**State Significant Development Application SSD-21208499**  
**Glanmire Solar Farm**  
**Site: 4823 Great Western Highway, Glanmire (Lot 141 in DP 1144786)**

I am objecting to the application to develop a 60 MW solar farm with a 60 MW / 60 MWh battery energy storage system and associated infrastructure (**Development**) as proposed by Elgin Energy Pty Ltd in State Significant Development Application SSD-21208499 (**Application**).

Glanmire Solar Farm
Indicative Site Layout Plan

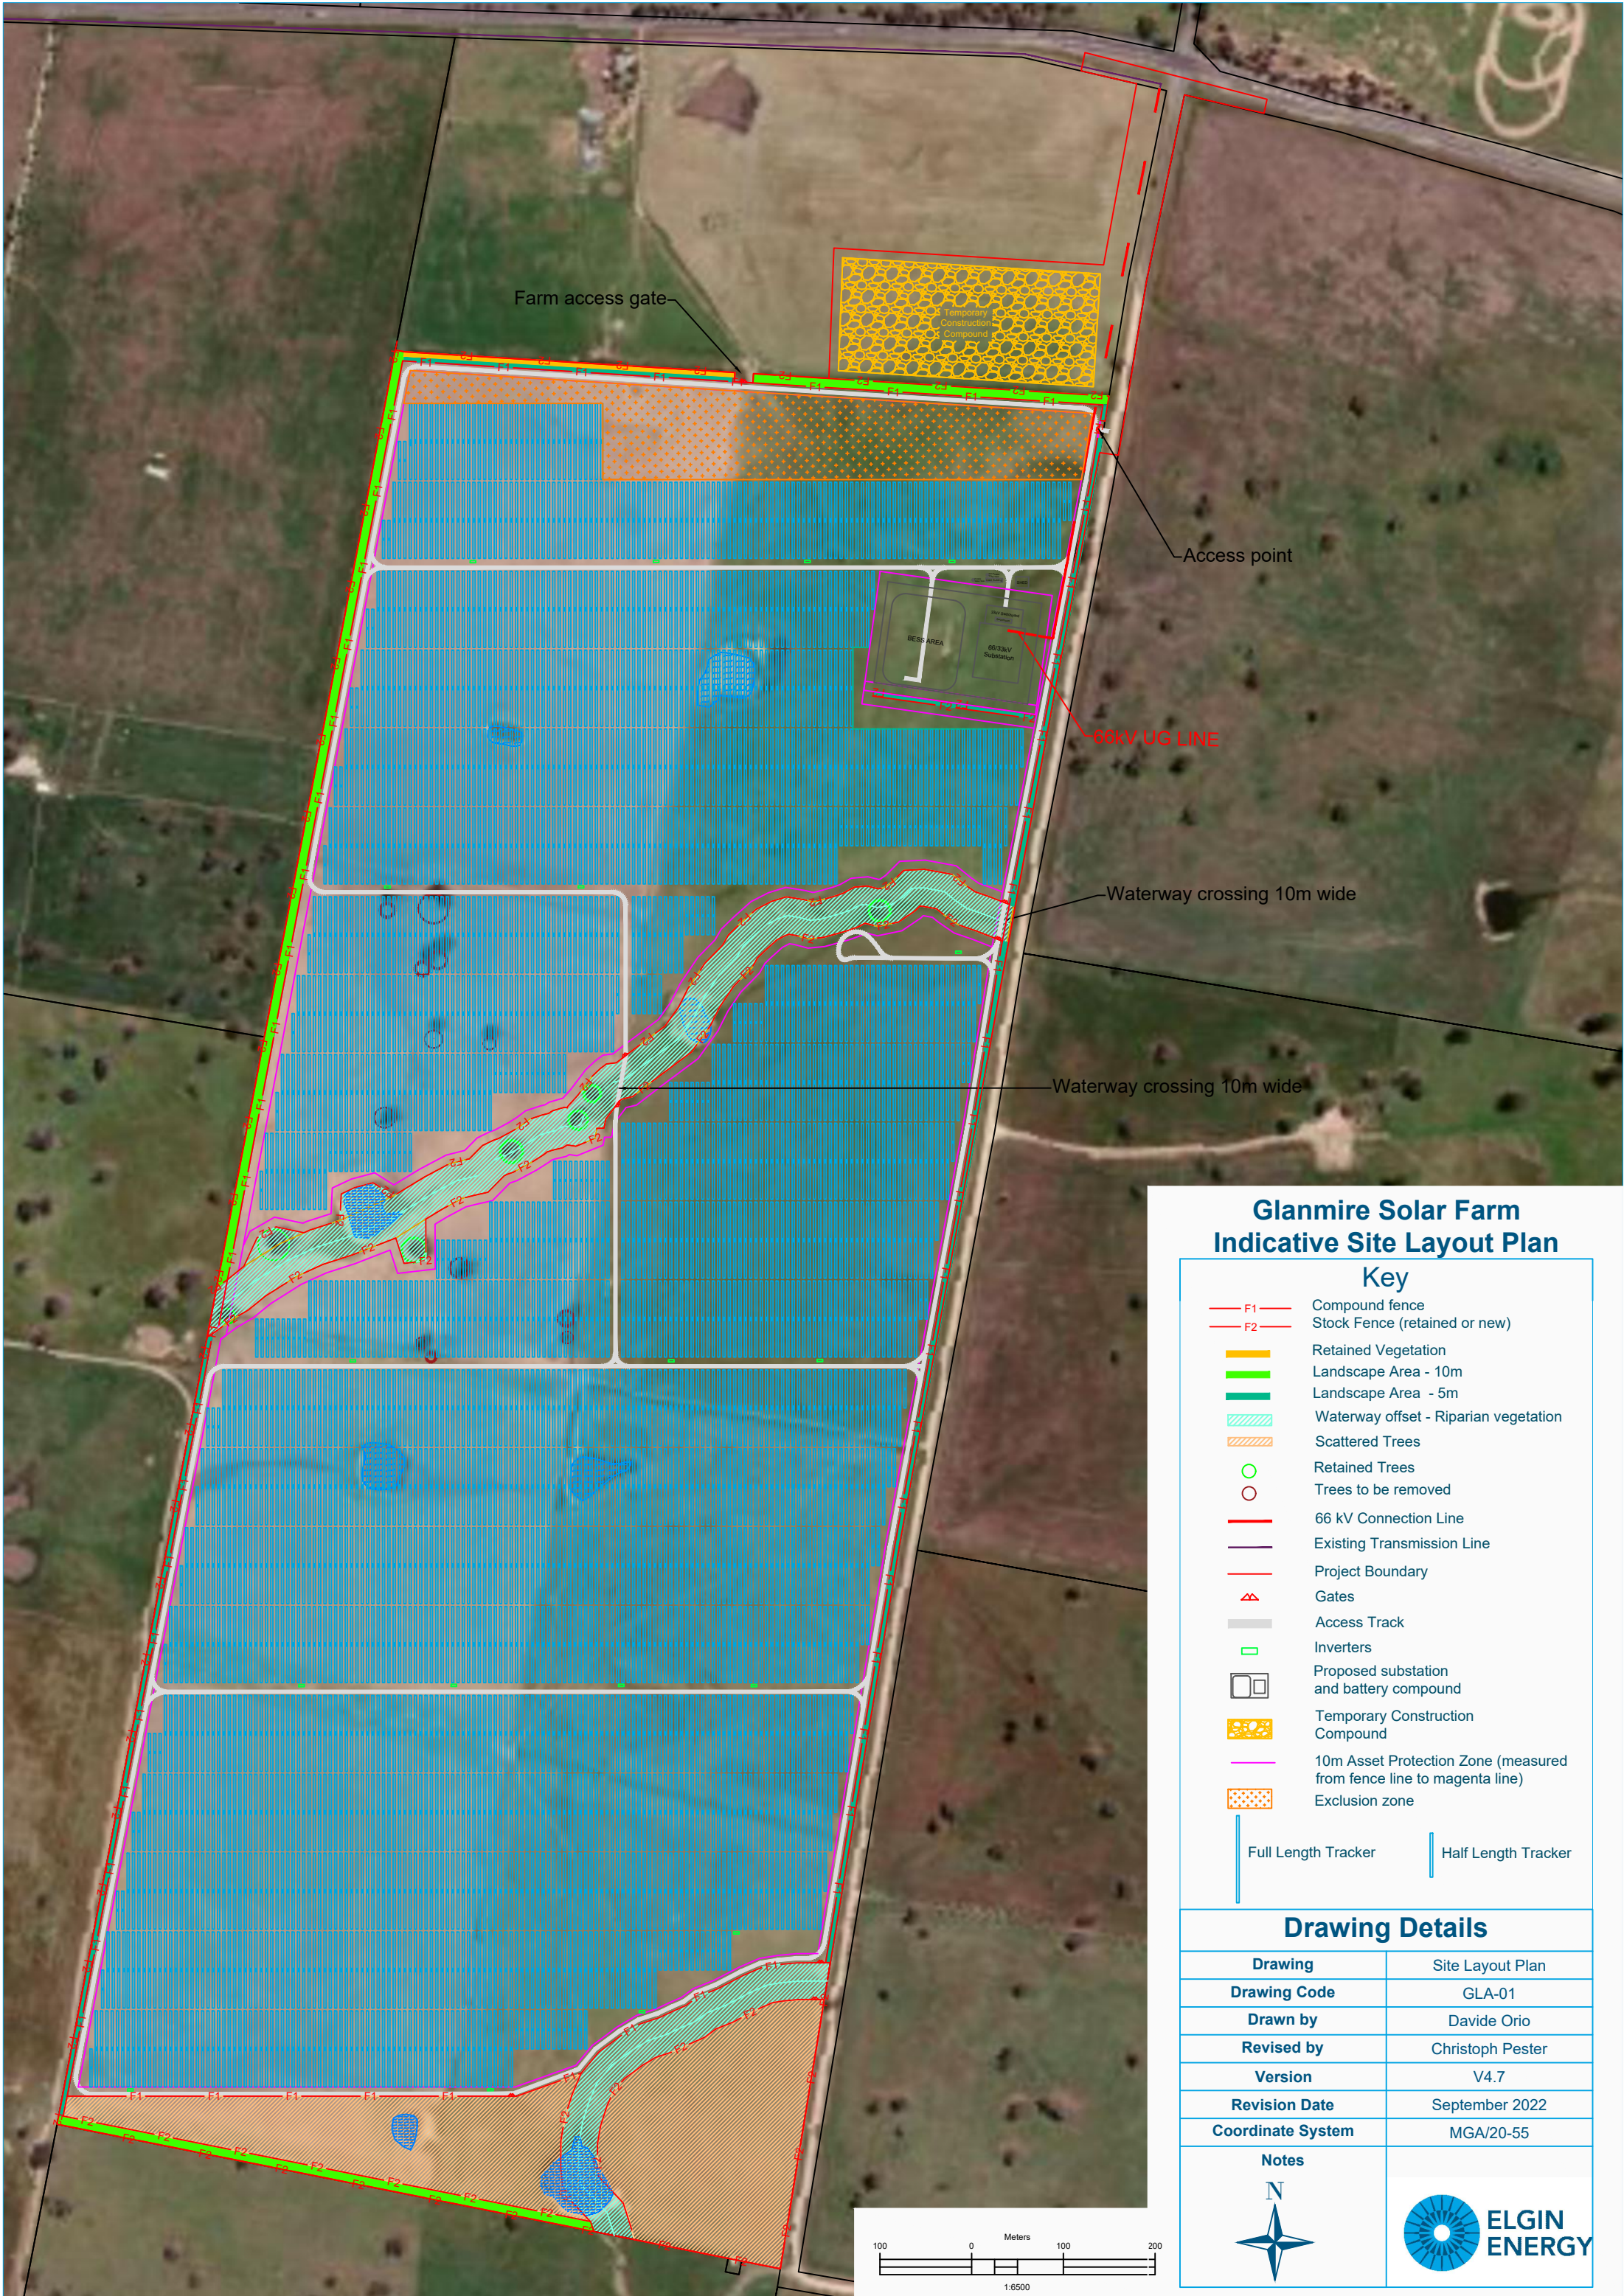
The Application proposes a 10m Asset Protection Zone (**APZ**). This APZ is the minimum requirement and is inadequate to mitigate against the risk of fire. It is also a totally inadequate setback and separation distance between the Development and my Land.

The need for a 30m setback is anticipated by the *Large-Scale Solar Energy Guideline* (August 2022), which states (pg35) that:

*Where a solar energy project is located adjacent to a horticultural or cropping activity, the solar array should be setback from the property boundary by at least 30m to mitigate any heat island effect.*

My Land is to be used for cropping activities.

It is my submission that, should the Development be approved, a minimum of a 30m setback should be imposed between the Development and my Land, so as to not in any way restrict the development or use of my Land. All mitigation should occur on the Site.
